APPLICATION NO: 20/00971/FUL/ADDINF

DESCRIPTION: Erection of Two Storey Side Extension, single storey rear Extension and Front Porch to Semi-Detached Dwelling

LOCATION: 21 Elliott Rise Ascot Berkshire

Proposed East Elevation  
1:100

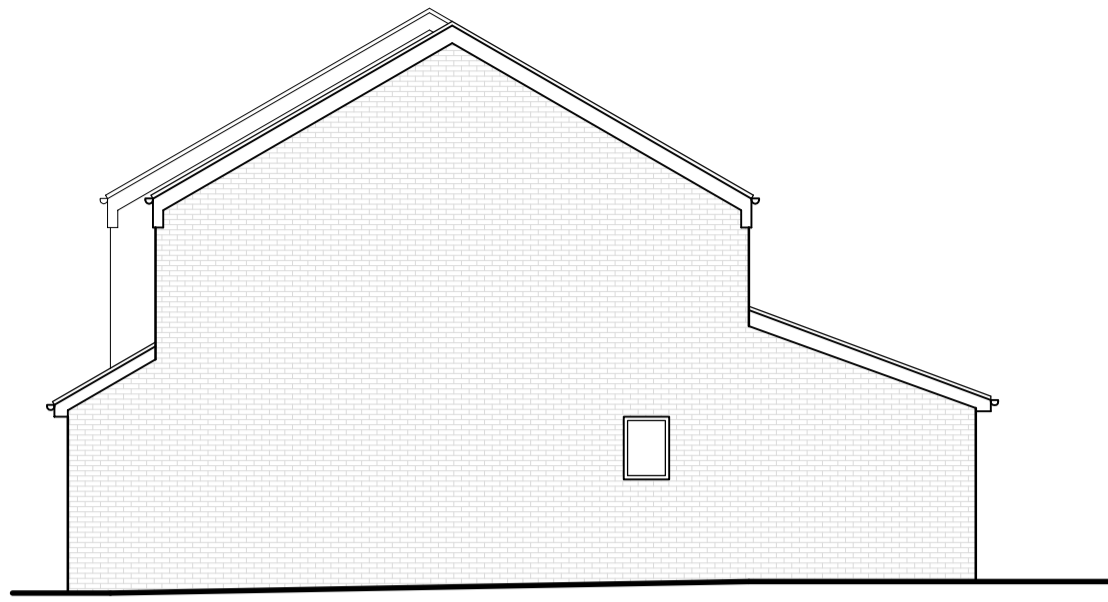
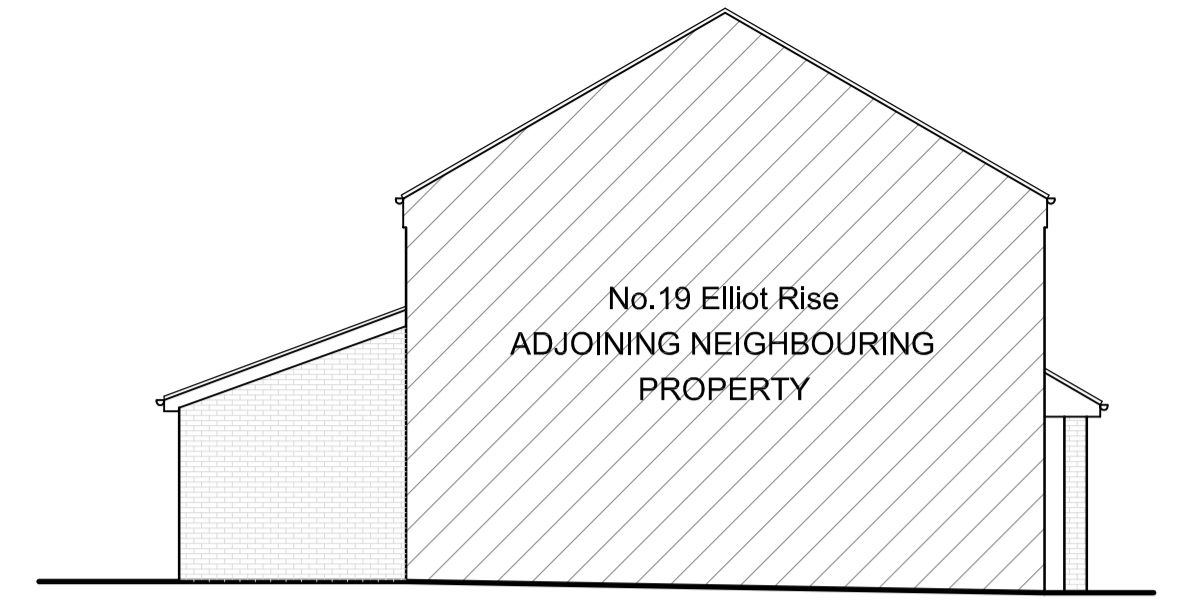
- 1 Please can you provide a roof plan of the proposed/existing development at a scale of either 1:200 or 1:500, including any roof overhang? This can be shown within the block plan or as a separate drawing.
- 2 Please could you confirm whether the roof lights are flush? If the roof lights protrude above 150mm then they will need to be shown on the side elevations.
